(Revised) STAFF REPORT

BIG CREEK TRAILS REZONE (RZ-15-00001)

TO: Kittitas County Board of County Commissioners
FROM: Kittitas County Community Development Services
RE: Big Creek Trails (RZ-15-00001)
DATE: ~~October 18~~ November 1, 2016

RZ-15-00001

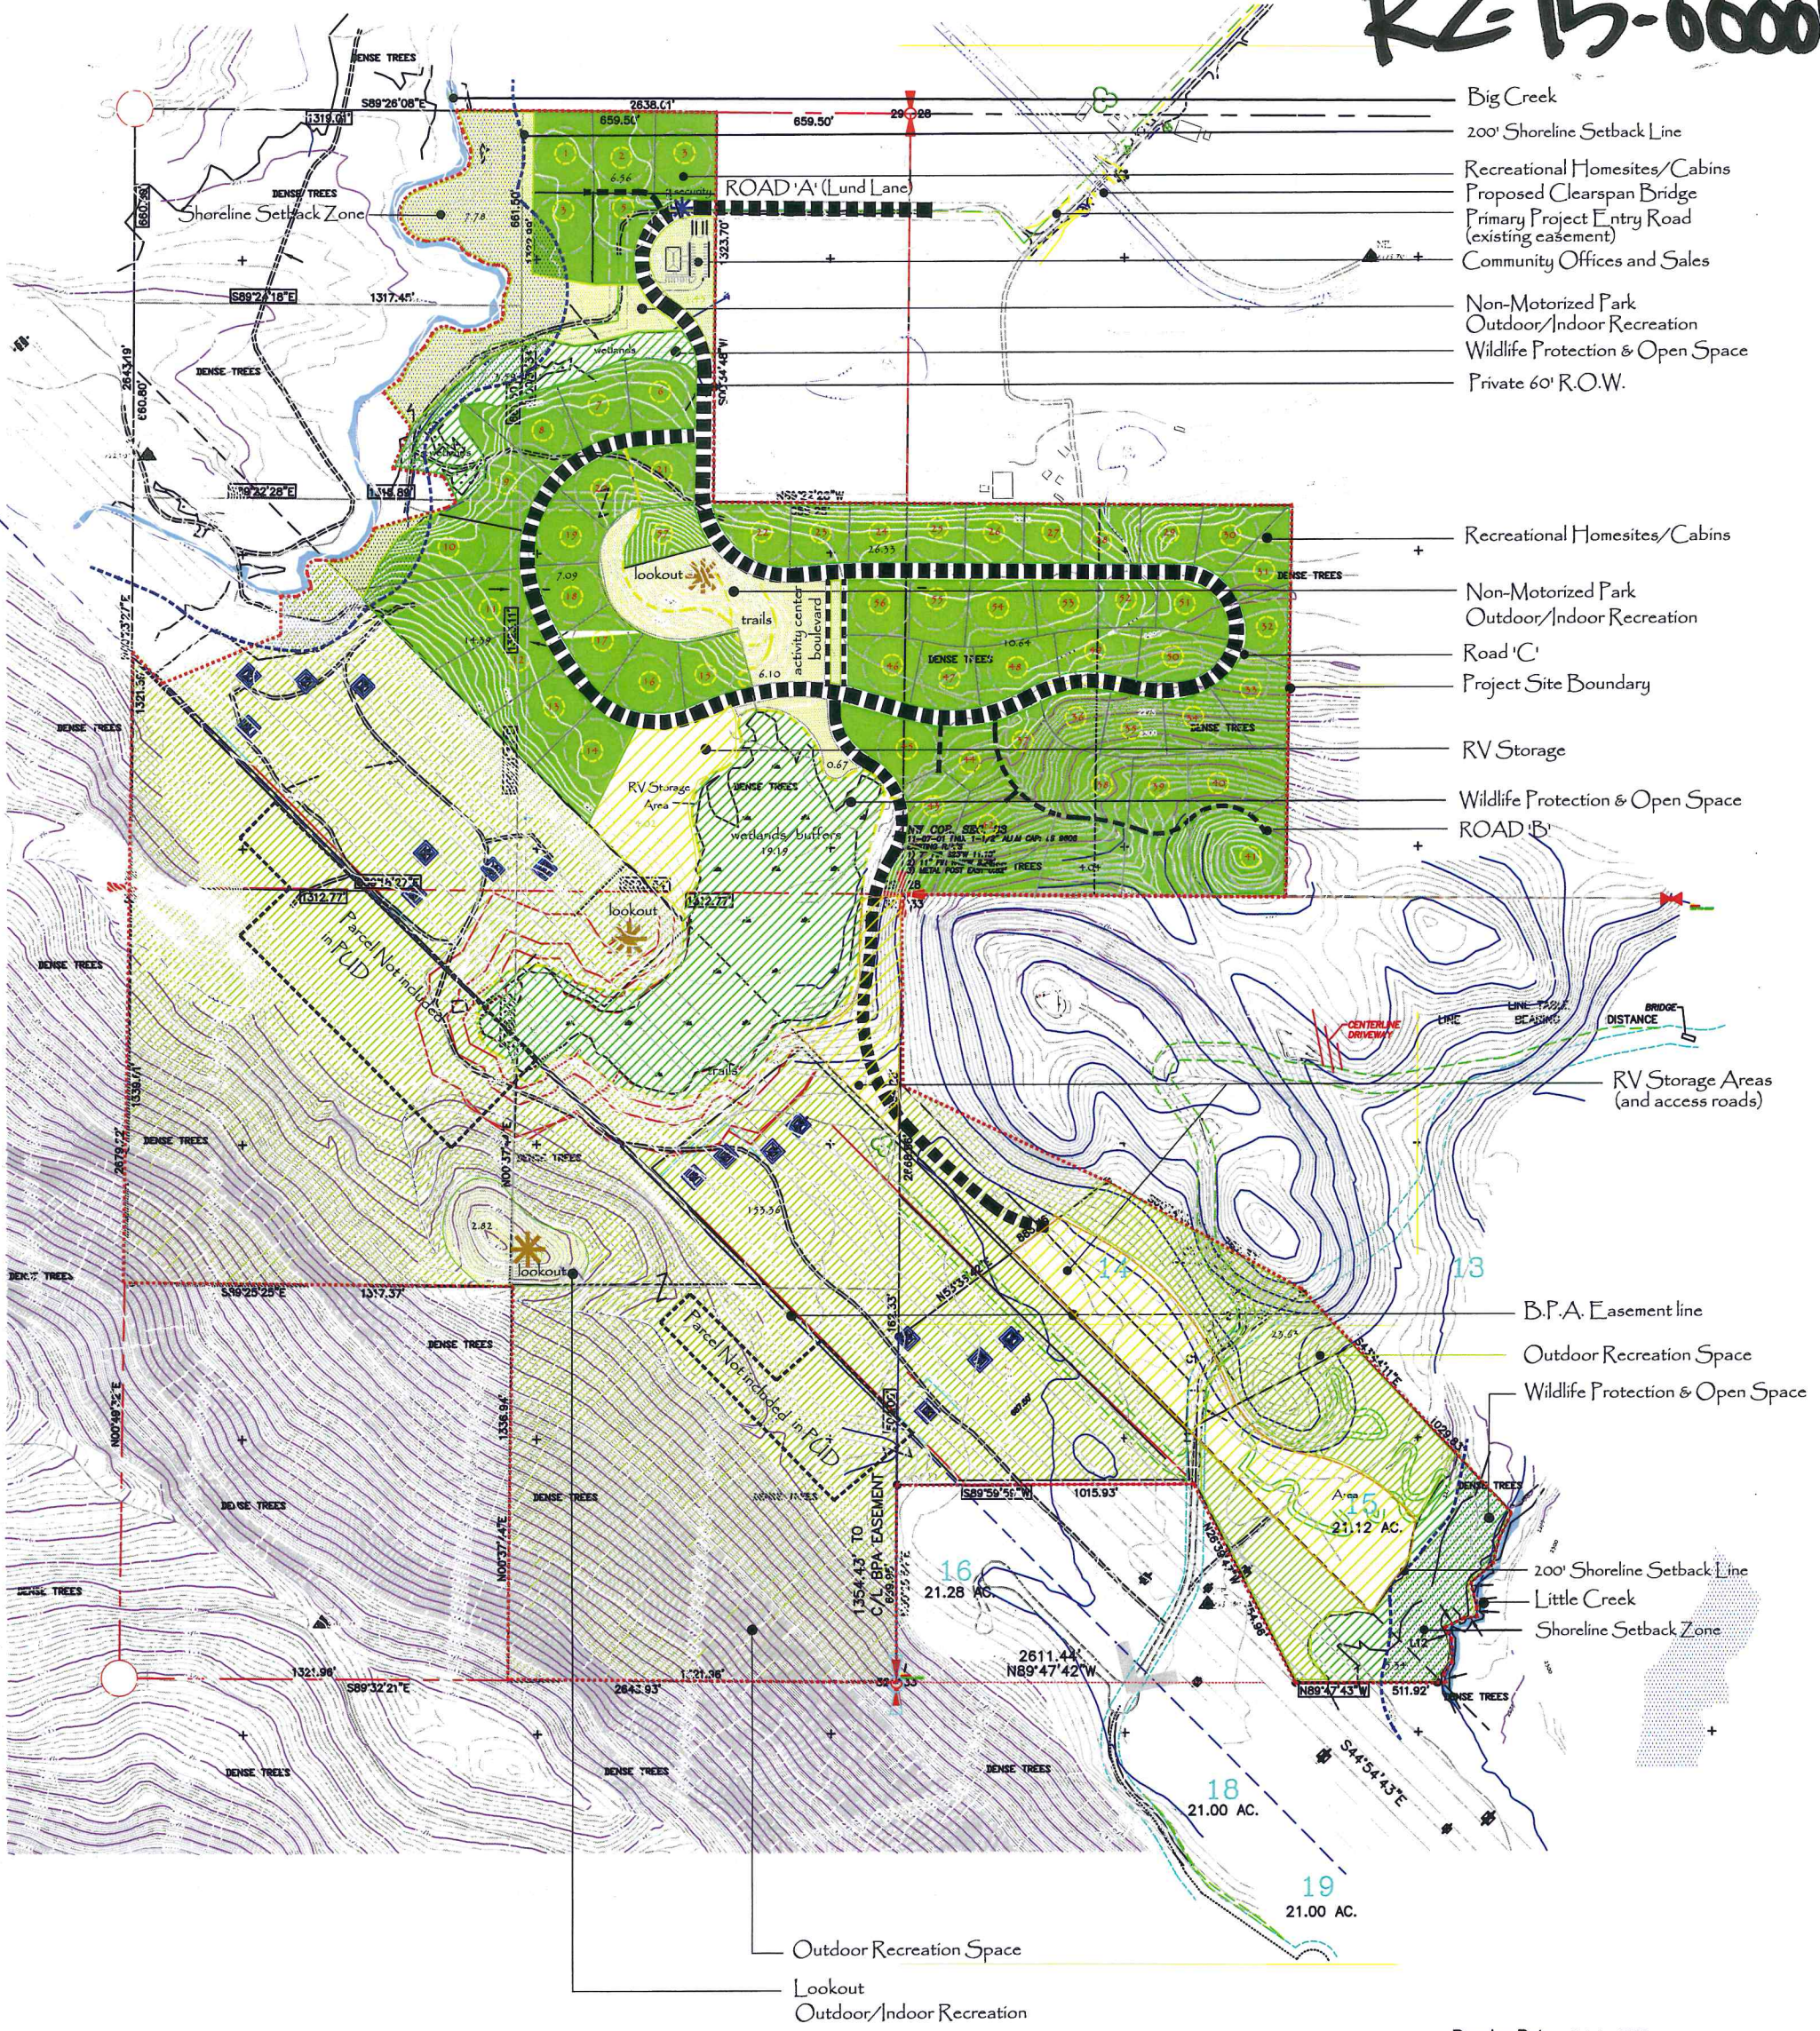
- d. The southerly most road depicted on the preliminary plan map shall dedicate a 60 foot easement for future connection with Misty Mountain Way.
- ~~e.~~—The Subject property ~~has is accessed via~~ a federally owned bridge (United States Bureau of Reclamation) and requires a replacement of the ~~existing~~ bridge built to County public bridge construction standards and transfer ~~of ownership to privately owned and maintained of the replacement~~ bridge to Kittitas County. Prior to approving any final plat, the applicant or successors must obtain the necessary permits through United States Bureau of Reclamation for the permanent crossing of the canal.

- j. The applicant shall relocate lots 57 and 58 to an area adjacent to or in close proximity to the larger residential area identified on the site plan that has been submitted with the PUD application as conditioned as follows:

- 1) The current planned residential foot print, identified on the site plan that has been submitted with the PUD application, may be enlarged a maximum of 7.5 acres to absorb the relocation of Lots 57 and 58 (identified on the site plan attached to the PUD application);

- 2) The current ~~design location~~ of the home sites that may be ~~redesigned-relocated within the site as long as any additional impacts are mitigated;~~ to absorb the relocation of these two home sites which may require further redesign of other components of the PUD layout;

- 3) The ~~The~~ road that was planned to connect the two home site foot print areas will not be required as the roads of the PUD will be built to the public road standards as defined in Kittitas County Code Title 12; and

- 4) The recreation storage area may be moved or split into two locations with one being located near or adjacent to the northern boundary of the BPA power line easement and not adjacent to the residential area.
